From: Simon Davis
Sent: 02 August 2022 17:20
To: Chris Pope 
Subject: RE: AW/104/22/PL 8 Gossamer Lane, Aldwick

8 Gossamer Lane
Appendix 7 - tree protection plan - 1

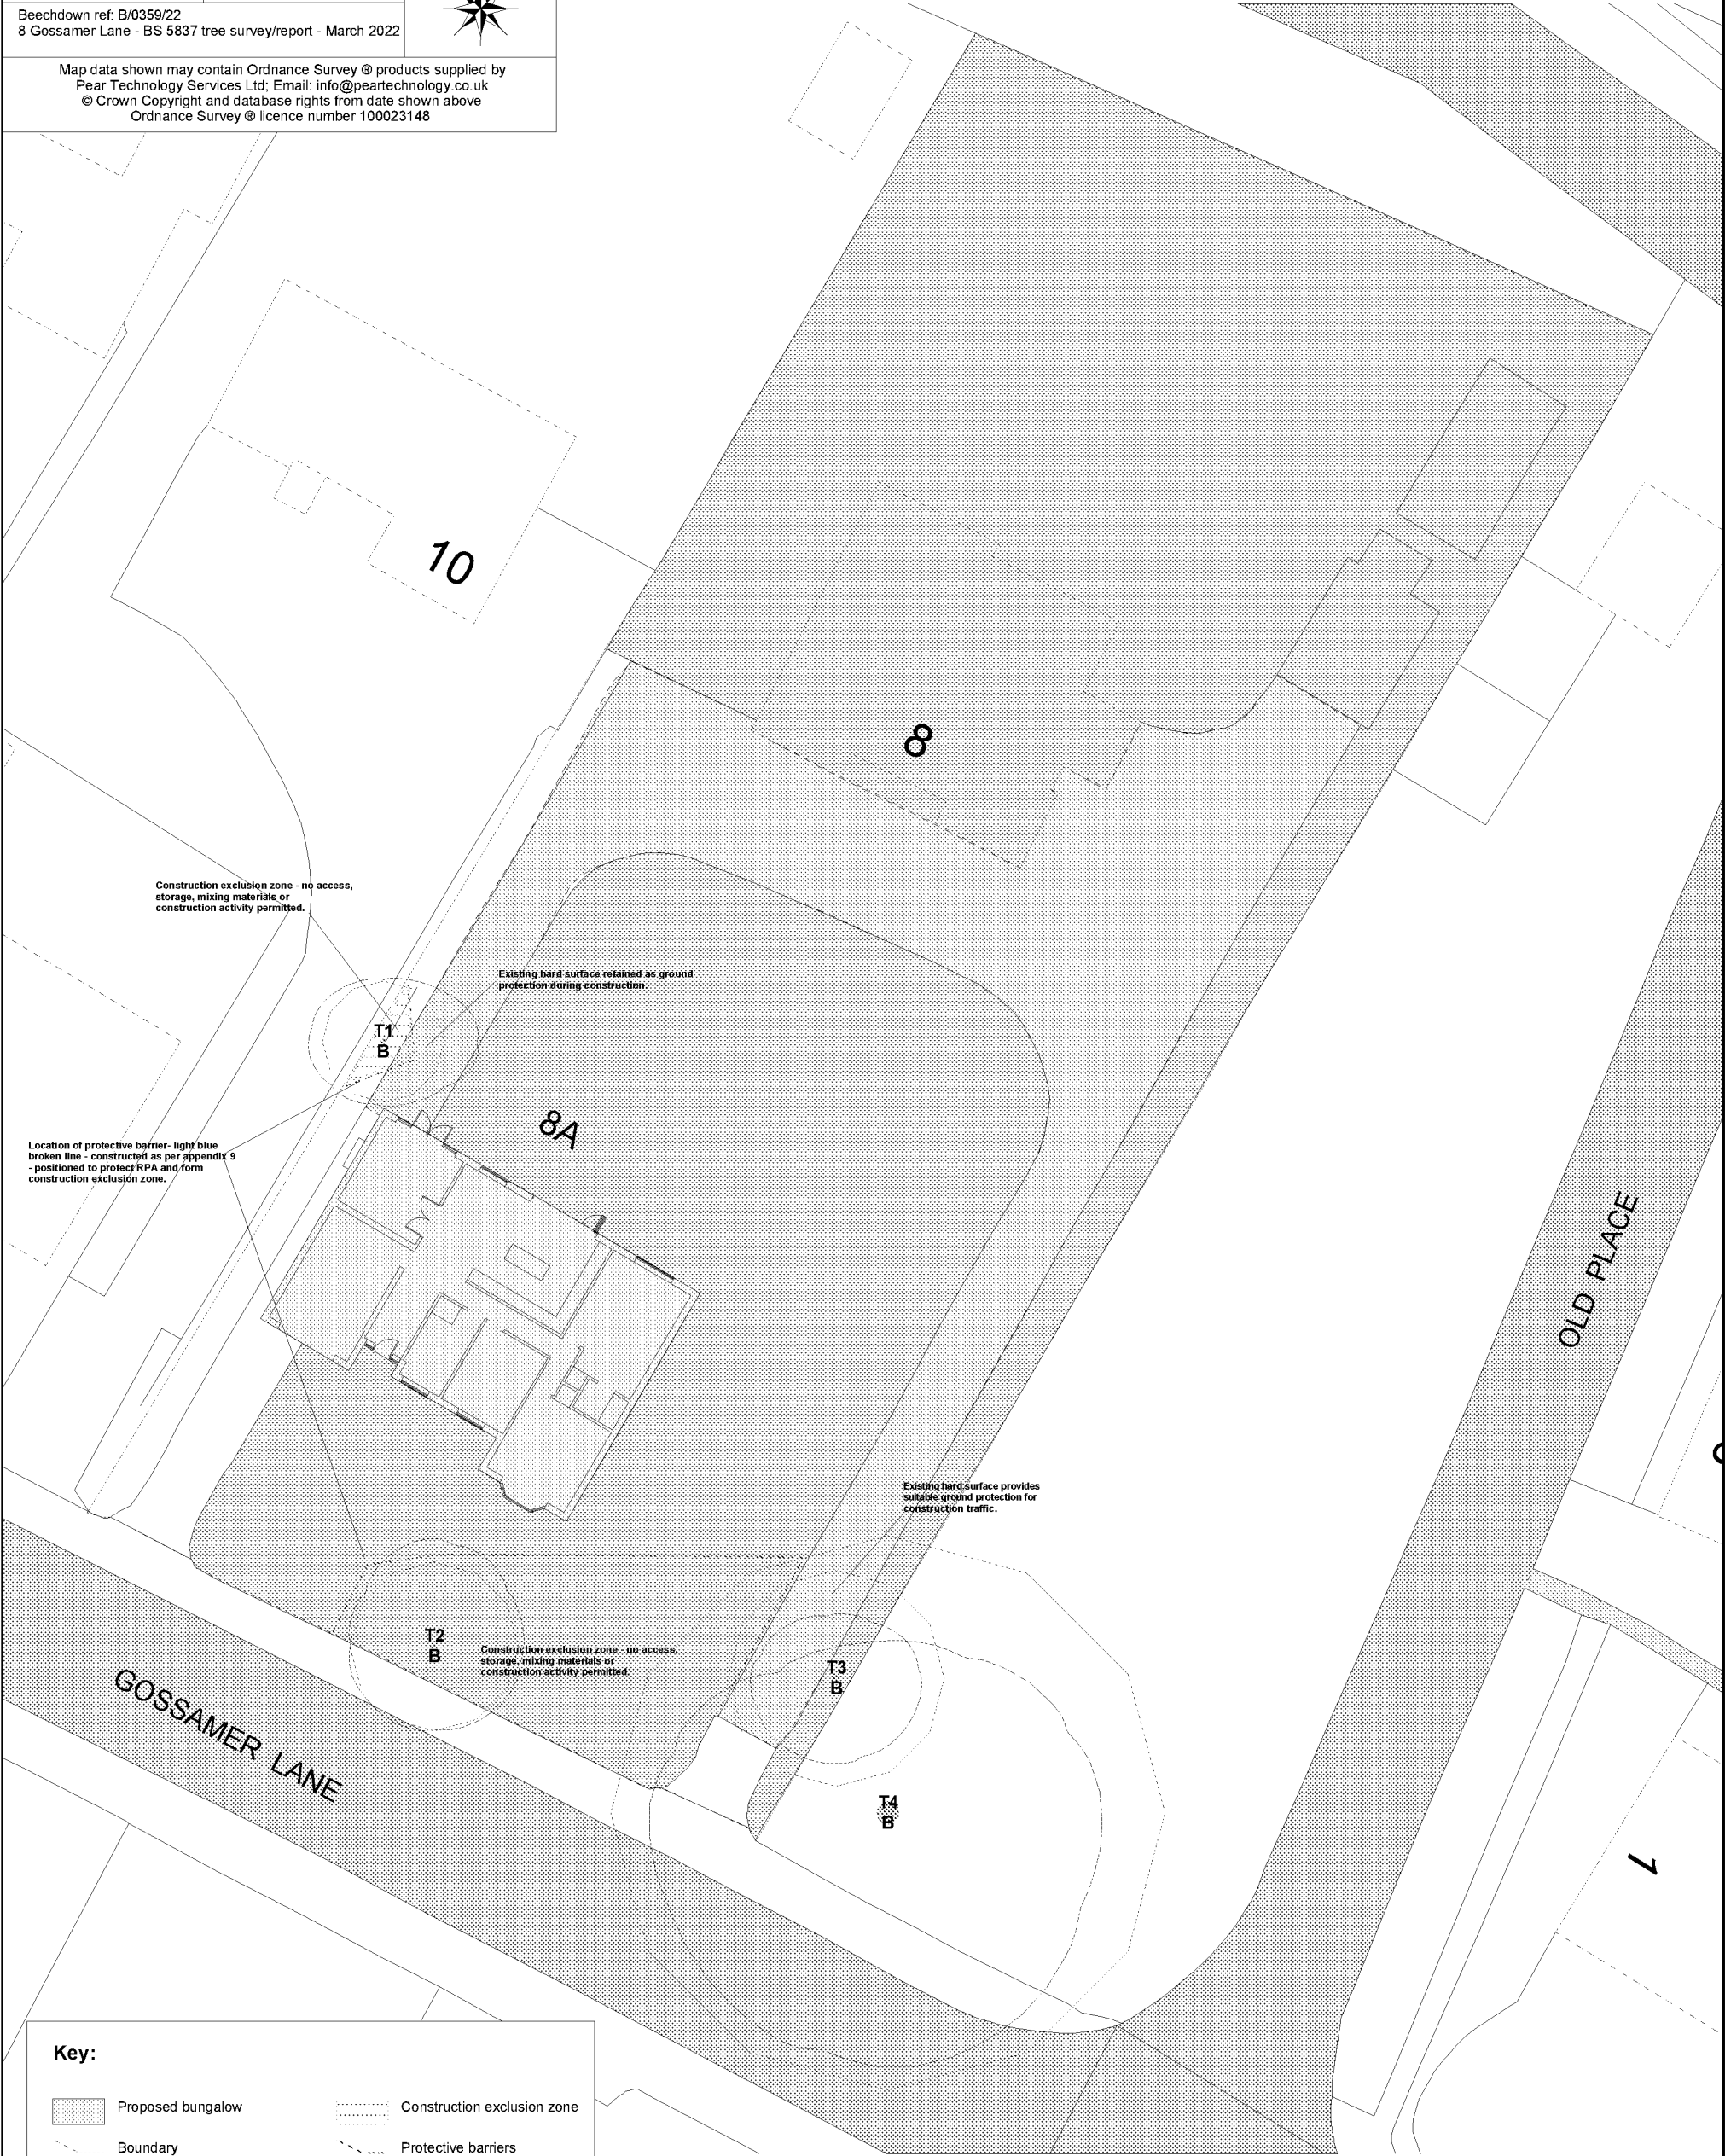
Before the site is occupied or any machinery is introduced to the site or demolition work or construction work or alterations to existing ground levels takes place (**excepting in respect of alterations to the western access point**), a PRE-COMMENCEMENT Site Meeting is to take place between the Planning Authority's Tree Officer and the Arboricultural Expert representing the site owner(s). At this meeting, all protective fencing and ground protection measures will be inspected to verify they are 'Fit for Purpose' as required under British Standard 5837:2012 and have been erected and positioned exactly as shown on the Tree Protection Plan which forms Appendix 7 of the Arboricultural Report by Jonathan Rodwell.
